**Application for Approval of Details Reserved by Condition
Town and Country Planning Act 1990
Planning (Listed Buildings and Conservation Areas) Act 1990**

Discharge of conditions 3 (preliminary risk assessment), 9 (drainage scheme), 10 (internal sound levels), 11 (ventilation scheme), 12 (flood evacuation plan), 13 (soft landscaping), 14 (construction environmental management plan), 15 (landscape and ecological management plan), 17 (bat roosting feature), 18 (electric vehicle charging), 19 (public open space), 20 (travel plan) and 21 (crime prevention) on previous permission 2018/90209 for change of use and alterations to mill to form 41 apartments (within a Conservation Area)

Union Mills, Tanyard Road, Milnsbridge, Huddersfield, HD3 4NB

Application Number: 2021/92009

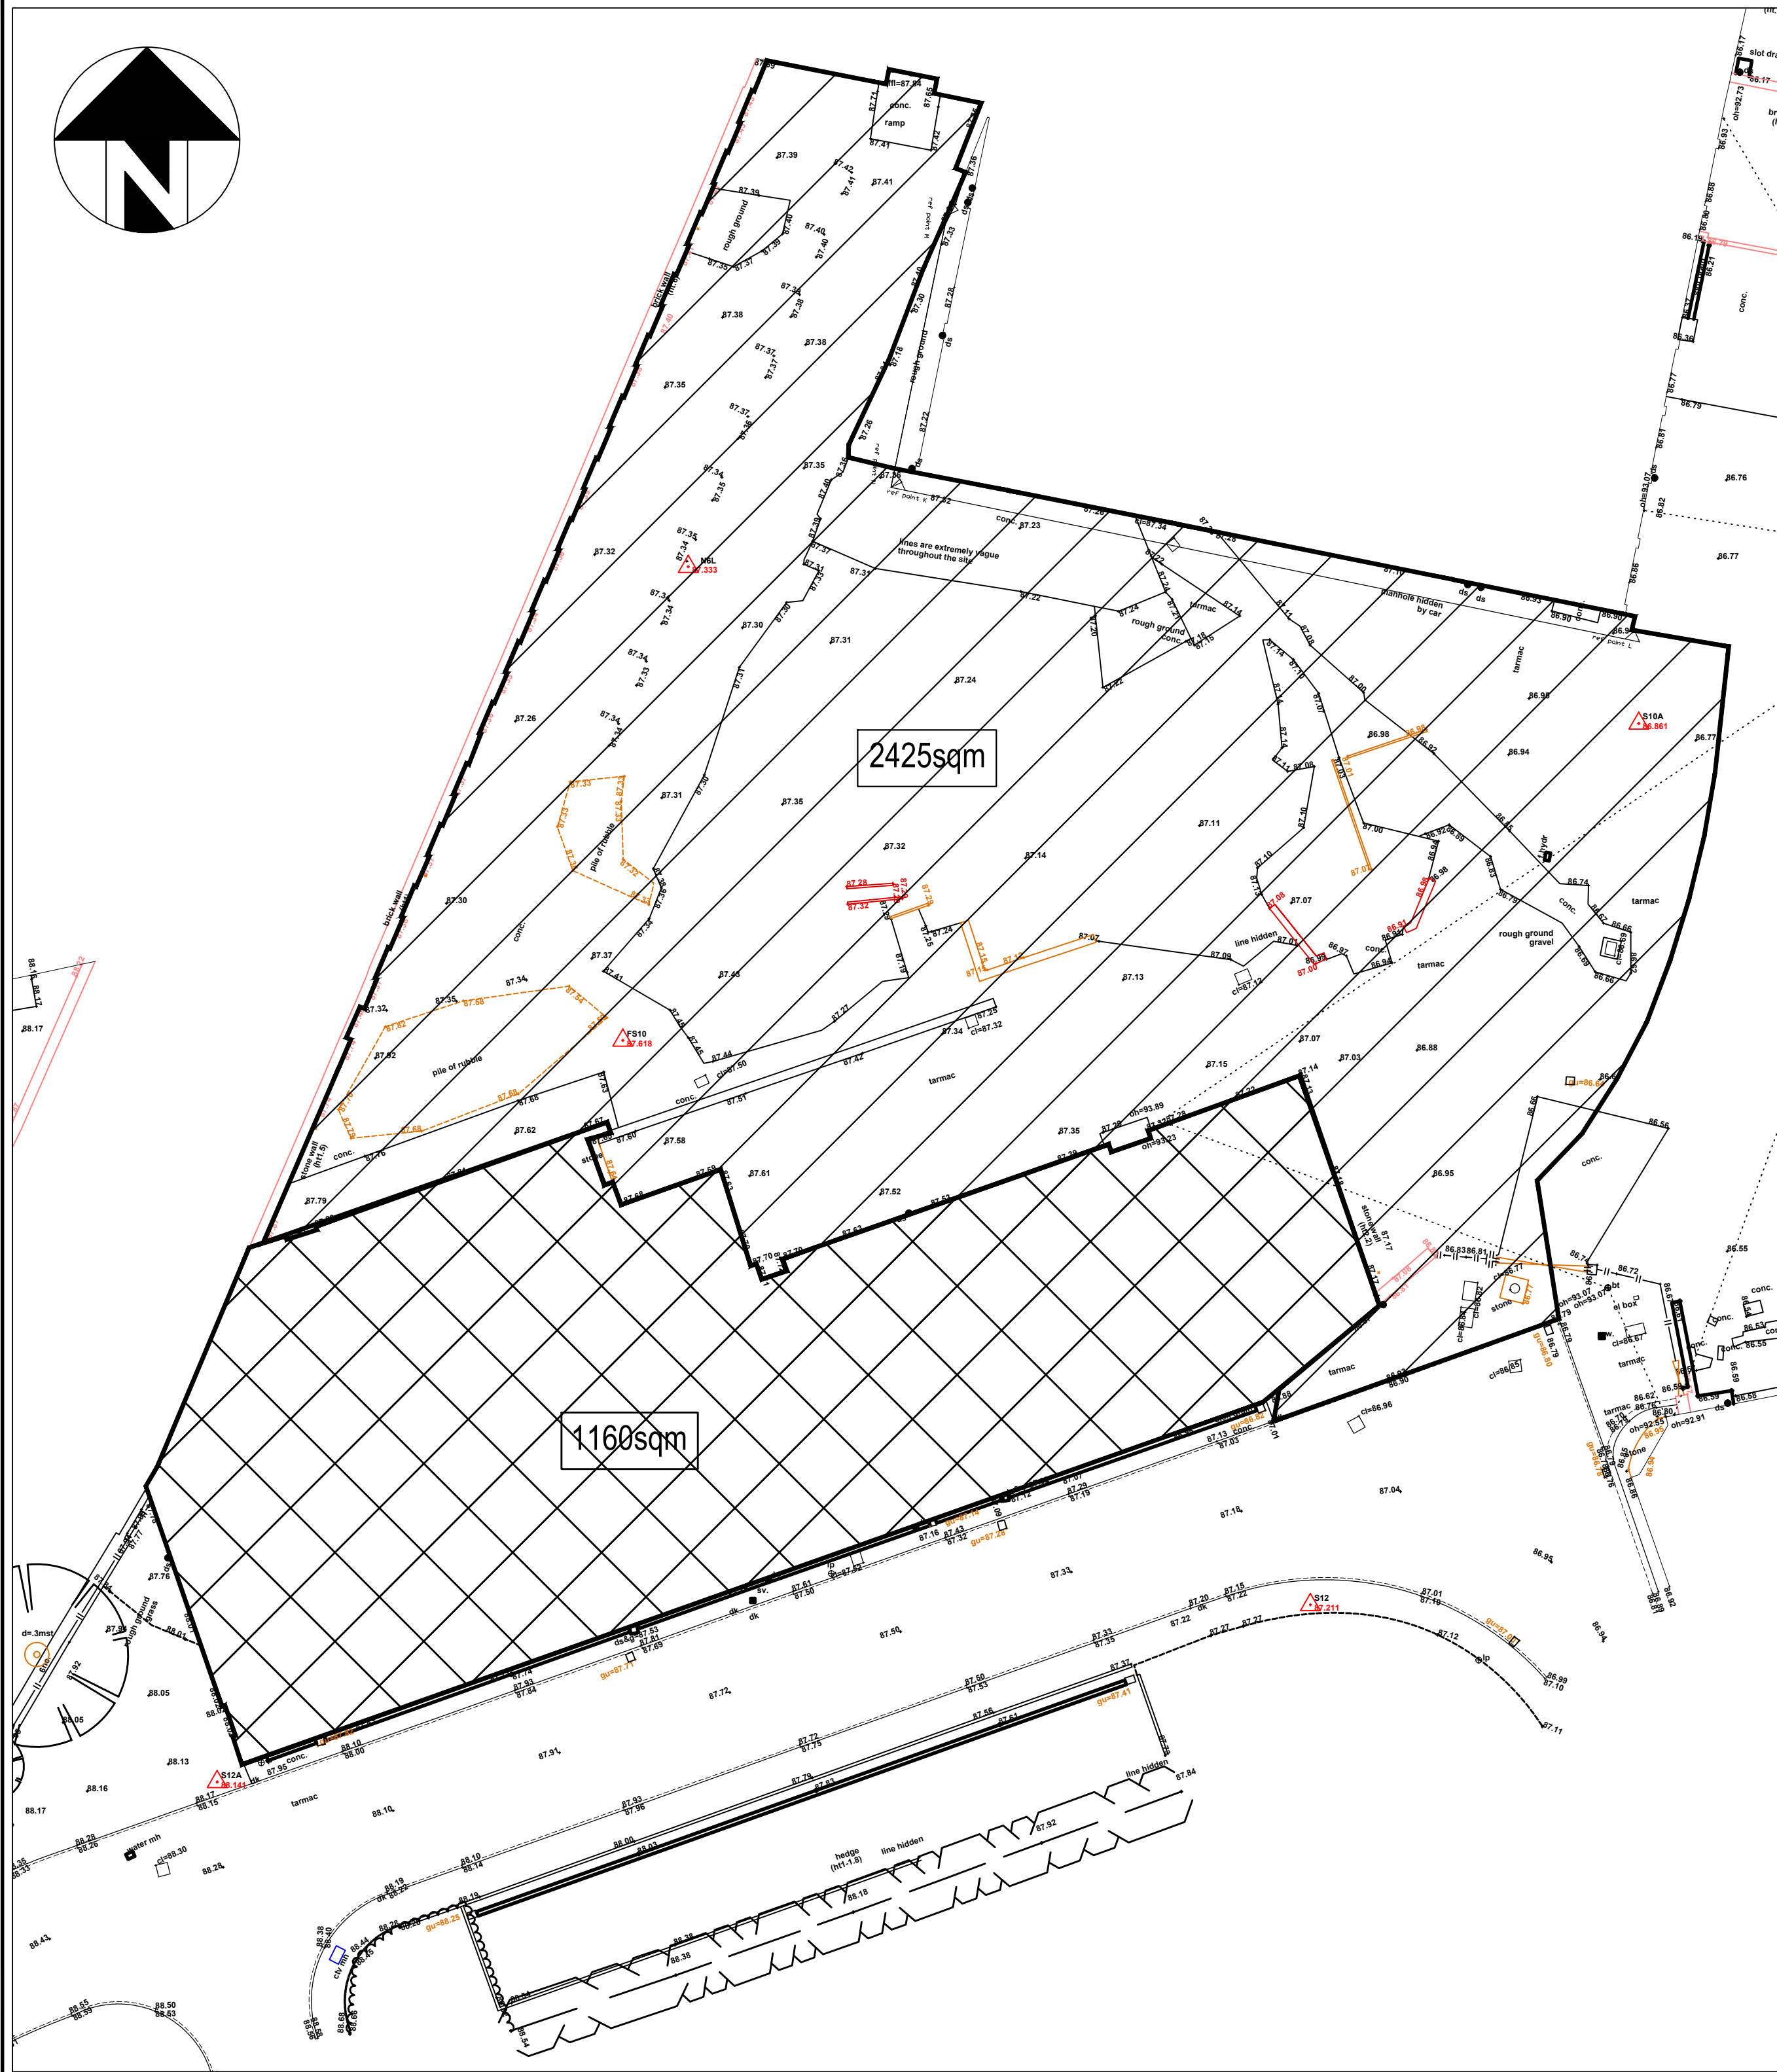
The proposed allowable discharge rate of 18 l/s and storage volume of 40m³ is acceptable. However, the use of a geocell type tank has not been justified and is not accepted at this time.

Geocell type tank cannot be easily inspected or maintained, and potentially could fail due to creep/failure of membrane over time with an overall low lifetime expectancy. Alternative methods of storage provisions, such as oversized pipes or concrete box type tanks, should be considered and the developer should assess these options. A maintenance regime for the surface water drainage system and details of who will be responsible for the long-term maintenance should be provided. These will require securing with a S106 agreement.

Ref: drawing no. (100)50 rev A : CAR CHARGING POINTS PUBLIC OPEN SPACE (POS) & LANDSCAPING DETAILS May 2021

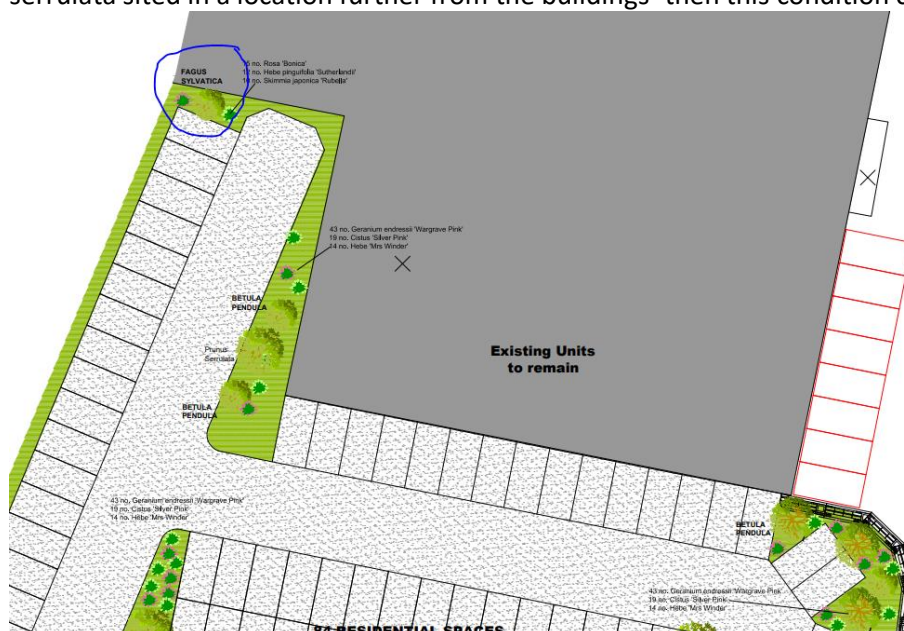
A *fagus sylvatica* (European beech) is proposed immediately adjacent to a neighbouring building. Due to the proximity, it will cause issues and should be swapped with the *prunus serrulate* proposed elsewhere within the site.
